# A303 Sparkford to Ilchester Dualling Scheme TR010036

## 7.7 Road Safety Audit

**ROAD SAFETY AUDIT**

<b>Regulation Number:</b>	Regulation 5(2)(q)
<b>Planning Inspectorate Scheme Reference</b>	TR010036
<b>Application Document Reference</b>	7.7
<b>Author:</b>	A303 Sparkford to Ilchester Dualling Scheme, Project Team, Highways England

WORK NO.53 VALE FARM LINK

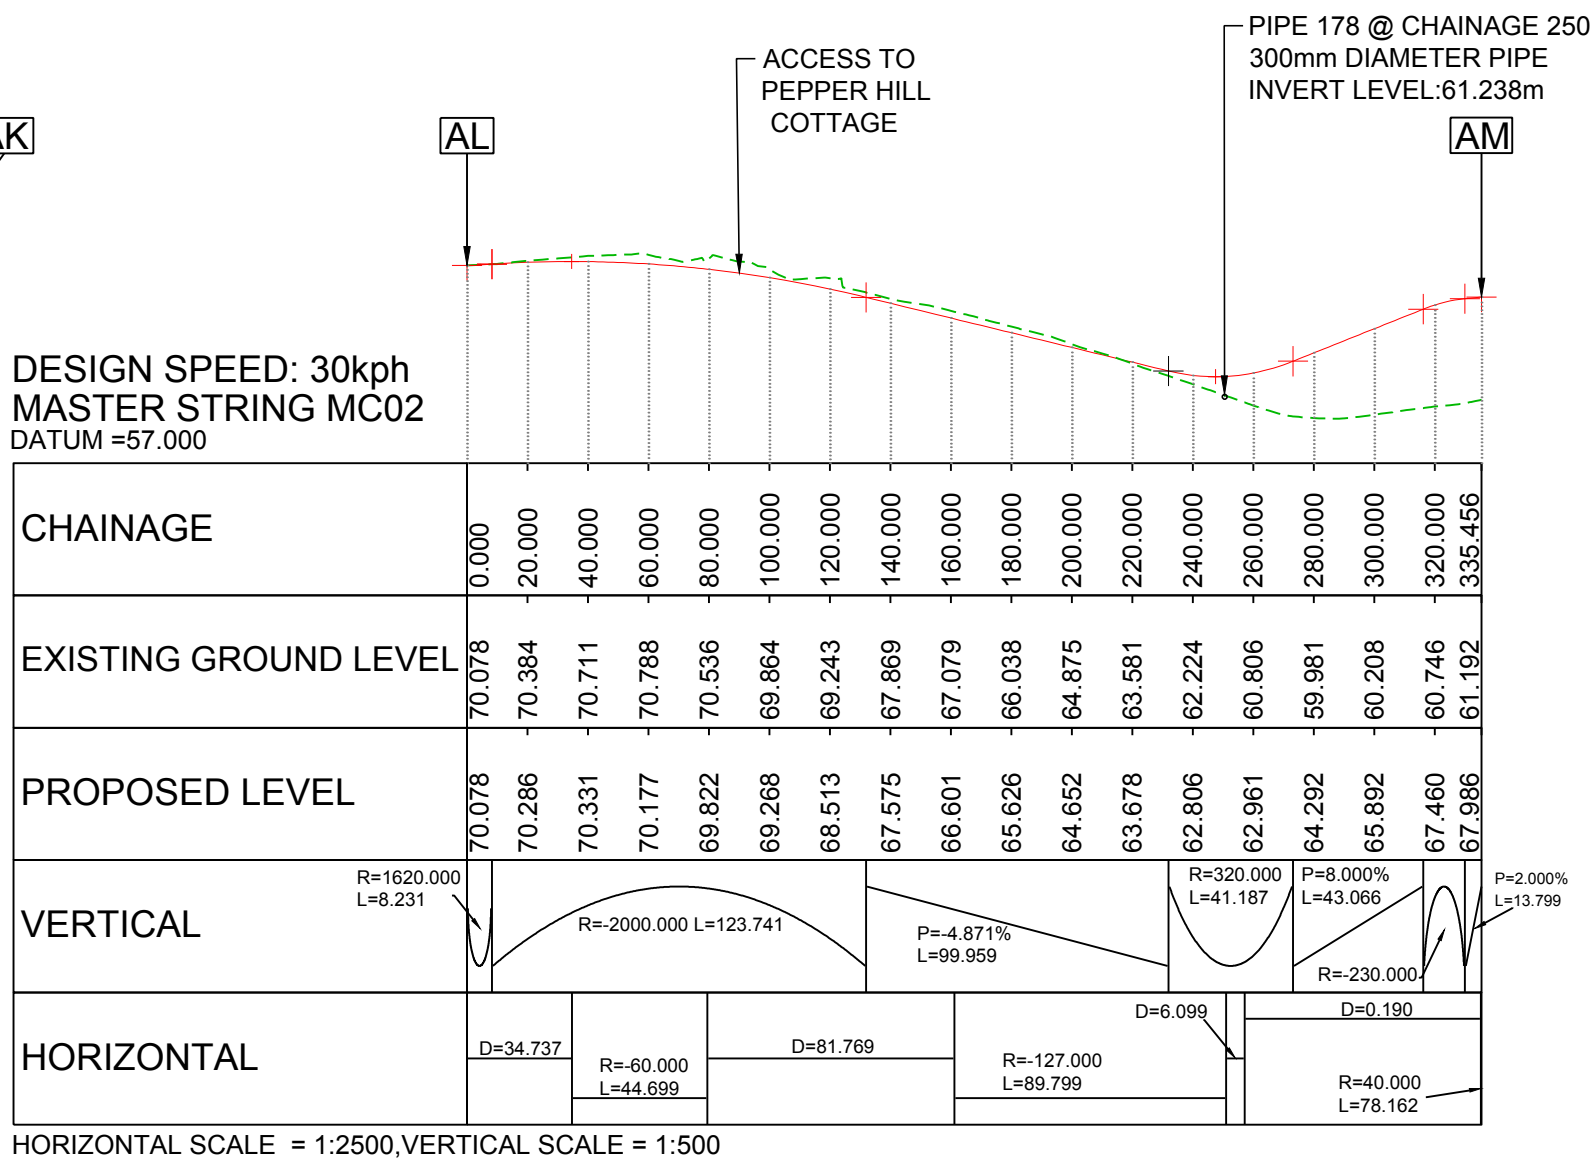
- Location: Camel Hill Link, at junction with Vale Farm Link.
- Summary: Appropriateness of junction type at end of slip-road.

4.6.1 At the end of the diverge from the new A303 eastbound carriageway a priority junction is proposed which provides access to Vale Farm. To the west of this junction, two-way traffic will be permitted on the Camel Hill Link.

#### 4.6.2 The proposed priority junction at this location may result in the following road safety issues:

- Motorists approaching the junction from the A303 eastbound, may do so at high speeds, due to the long and straight alignment of the off-slip road. This has the potential to increase the risk of collisions, particularly at the new priority junction where slower vehicles may be turning into Vale Farm Link.

- It is unclear if left-turn manoeuvres into Vale Farm Link will be permitted. The Audit Team is concerned that if no deceleration lane is provided then vehicles slowing to carry out a left turn manoeuvre will be at risk of rear end shunt-type collisions with (potentially faster) traffic following behind.

- Motorists travelling westbound on Camel Hill Link (a two-way road) may not fully appreciate that access is prohibited beyond the Vale Farm Junction. Due to the alignment, there is a concern that vehicles will be able to join the A303 eastbound off slip, in the wrong direction, which is likely to result in head-on collisions.

- Drivers on the A303 eastbound off-slip may not anticipate oncoming (westbound) vehicles on Camel Hill Link, to the west of the Vale Farm Junction, particularly at night when only headlights can be seen at distance. This could result in sudden lane changing or braking manoeuvres increasing the late braking and / or loss of control collisions on the A303 eastbound off slip.

#### 4.6.3 It is recommended that the form and function of the junction at Camel Hill Link / Vale Farm is reviewed.

4.6.4 The Audit Team is of the opinion that a roundabout may better serve traffic movements at this location and could address many of the issues highlighted (including the potential for high eastbound approach speeds and conflicts from turning movements).

4.6.6 The layout design has been changed from a T Junction to a roundabout (see updated drawings in appendix B).
